Engineers Comments Regarding Surface Water Drainage

Application Reference:	AL/4/26/DOC	Reviewer Reference:	ADC/EXT2/96
Planning Officer:	Hebe Smith	Date of Review:	26/03/2026
Site Name:	Stanwick Northfields Lane Westergate PO20 3UH		
Application Description:	Approval of details reserved by condition imposed under AL/70/24/HH relating to condition 3-surface water drainage.		
Assessment Number:	1

Application Reference: AL/4/26/DOC Site Name: Stanwick Northfields Lane Westergate PO20 3UH	Initial Issue Date: 26/03/2026 Issue Date: 26/03/2026 Reviewer Reference: ADC/EXT02/96
--	--

Proposed Extension and Alterations
at Stanwyck, Northfields Lane, Westergate
for Mr and Mrs G Vos
Drawing F20e August 2024 Scale 1:100 @ A2
Proposed Drawing - Existing & Proposed Floor Plans with externals

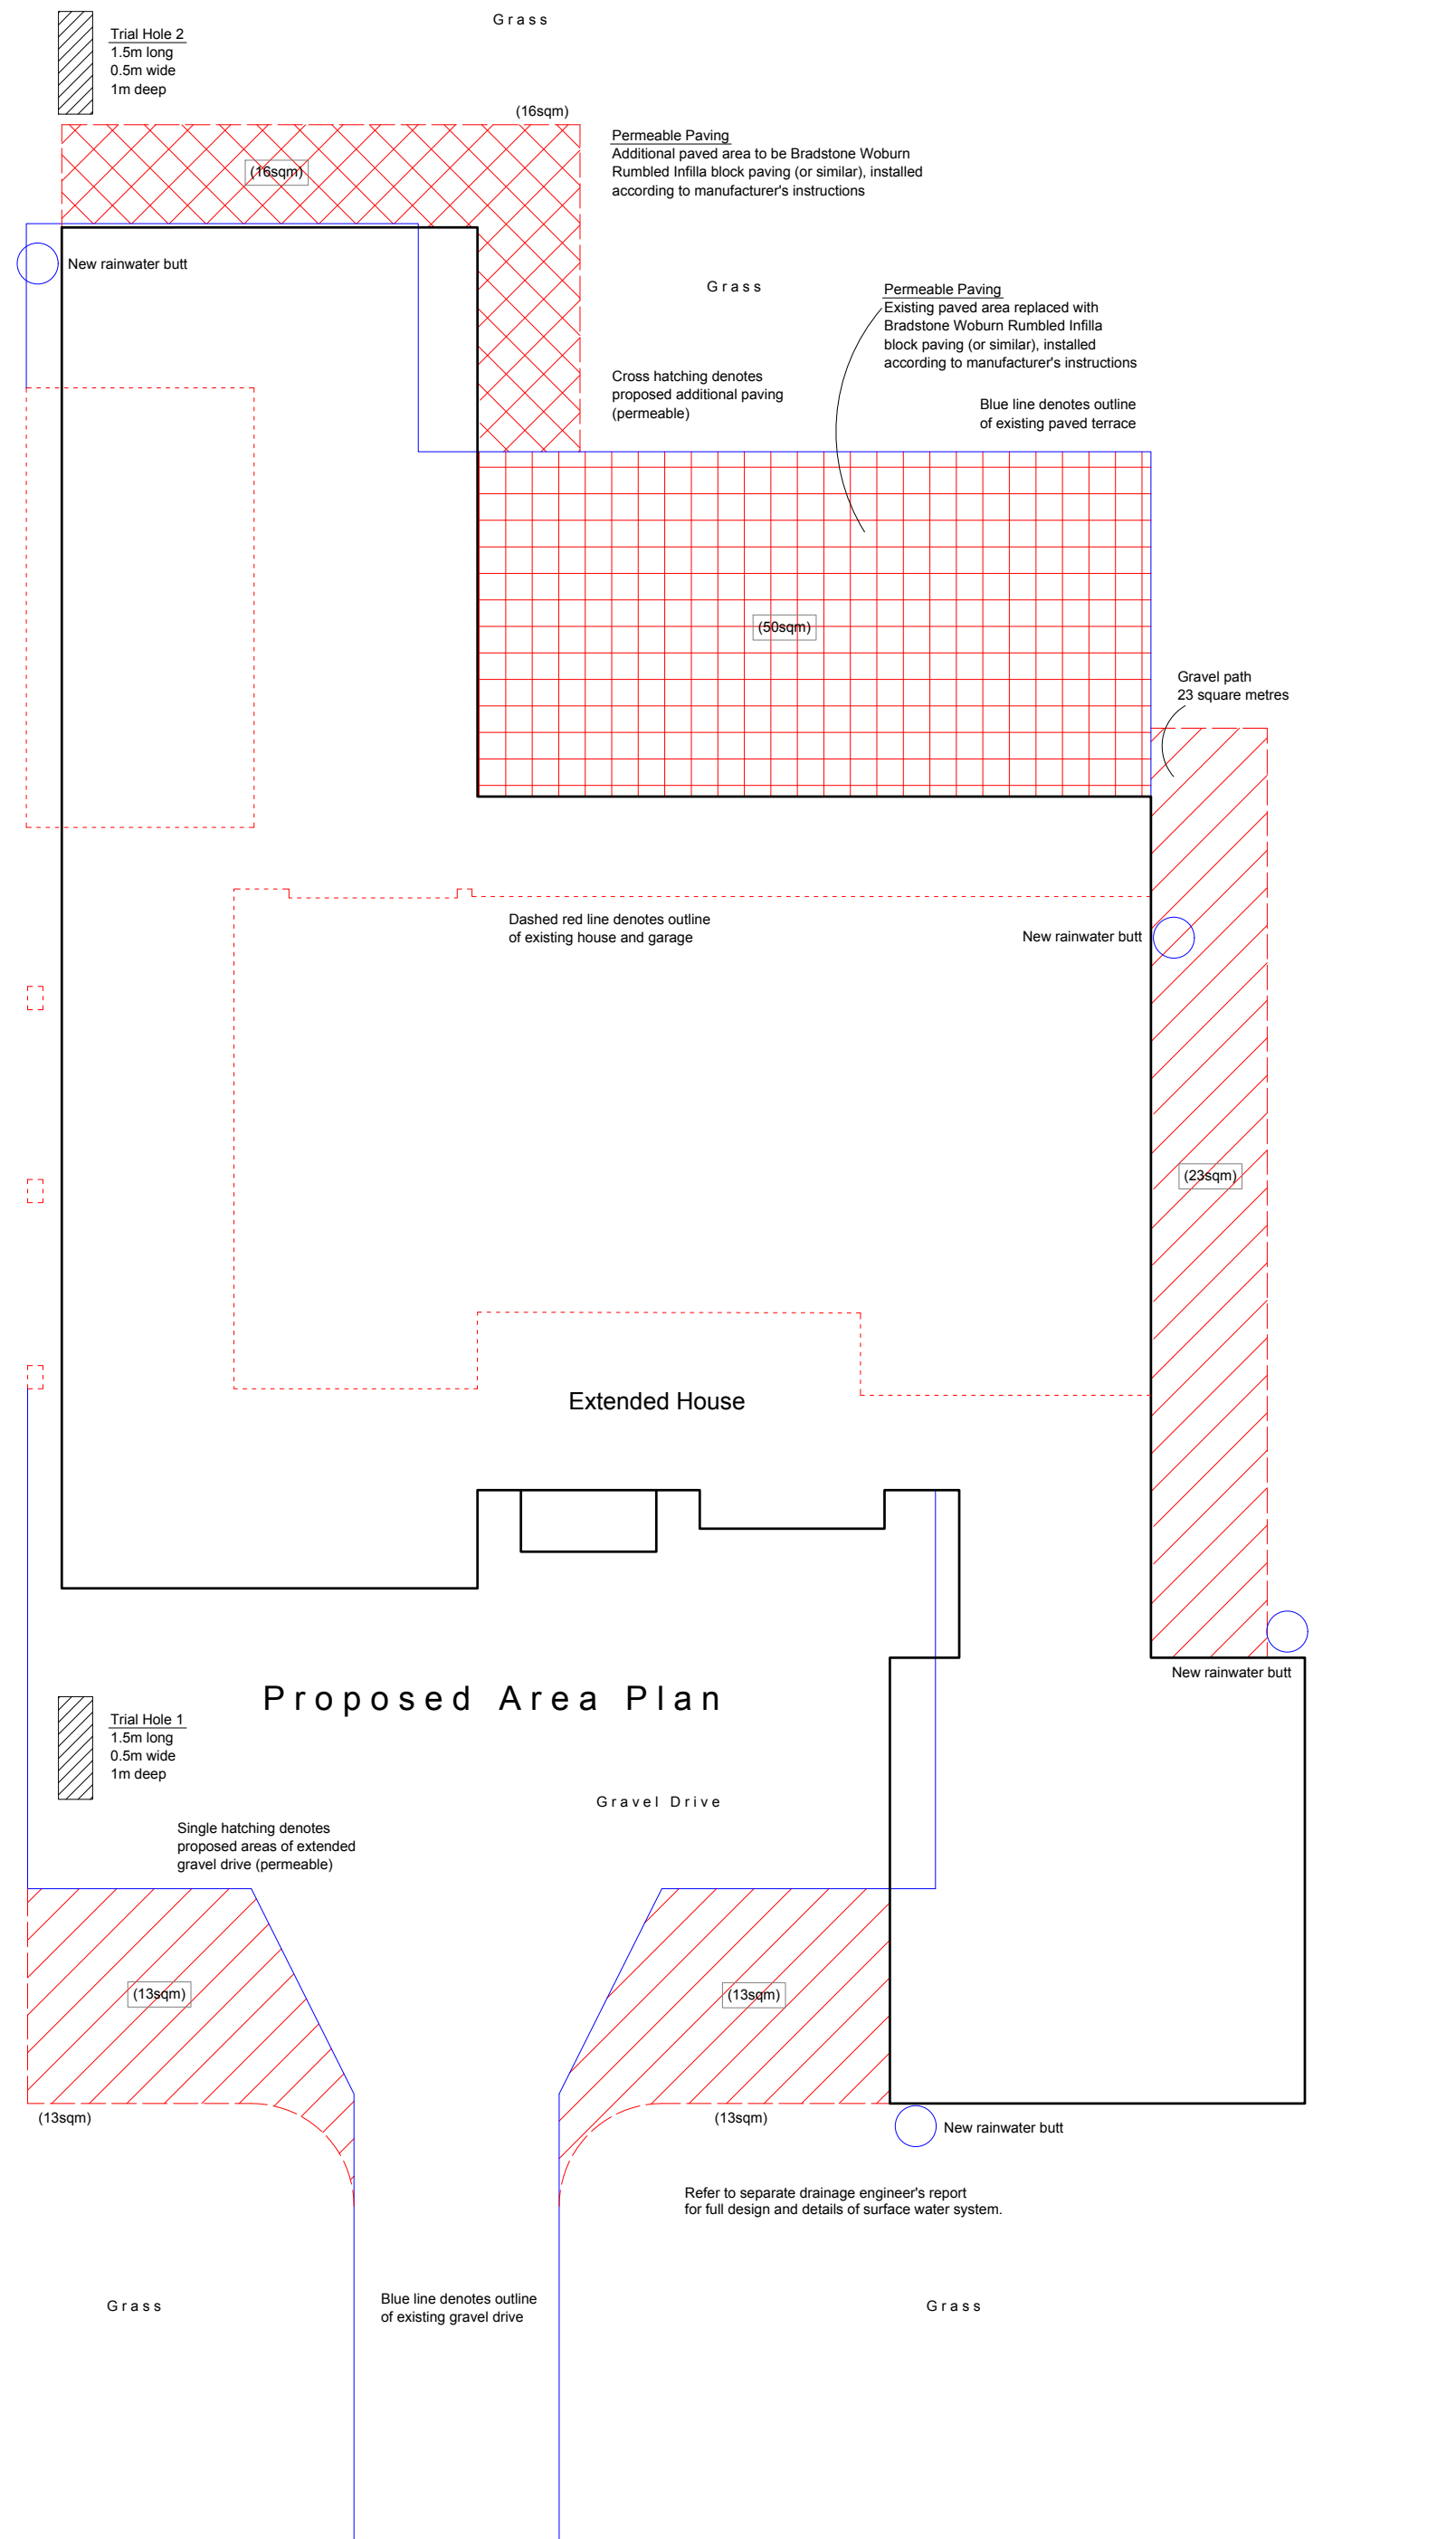
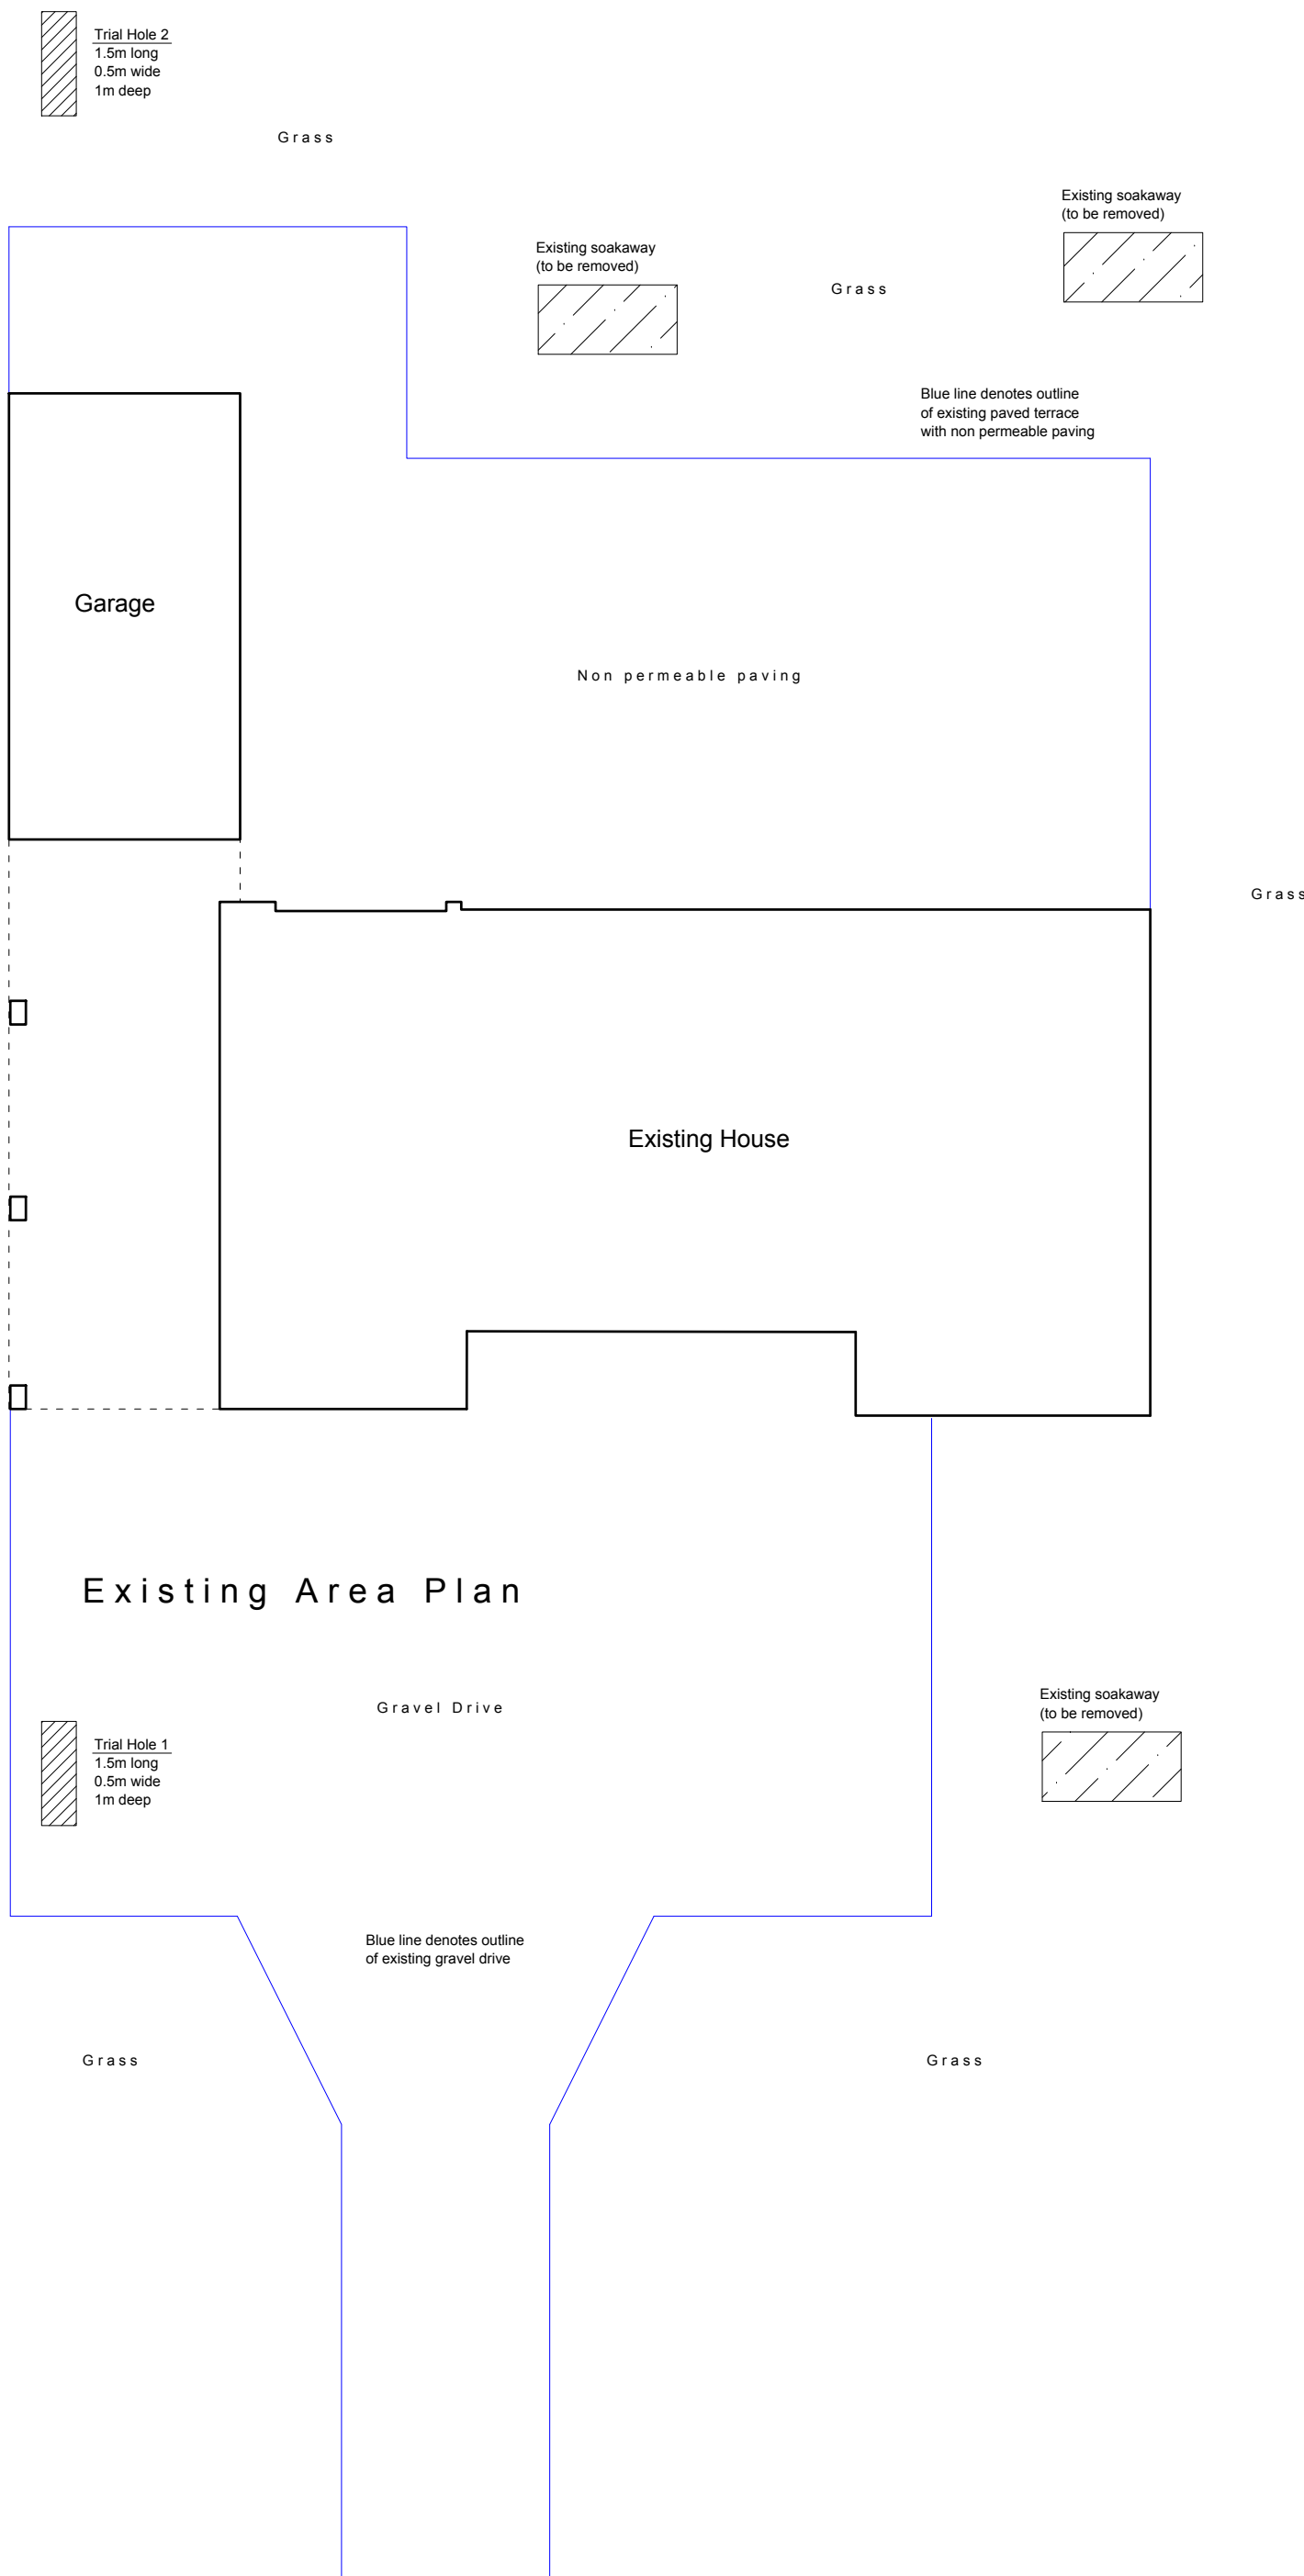
Comment Number					
1.	Rainwater reuse must be proposed where possible in accordance with the hierarchy for sustainable drainage. Water butts are an effective way of achieving water reuse and interception drainage.	Water butts are included in the revised design and are acceptable for the type and scale of development. Comment closed.			
2.	It is unclear if any existing site drainage features or infrastructure exist and if so, what will be retained or decommissioned. Please clarify.	Existing infrastructure is now shown on the drainage layout plan. Comment closed.			
3.	The site is in flood zone 2, partially in flood zone 3 and at low risk of surface water	From the information provided in the Drainage Statement and review of out
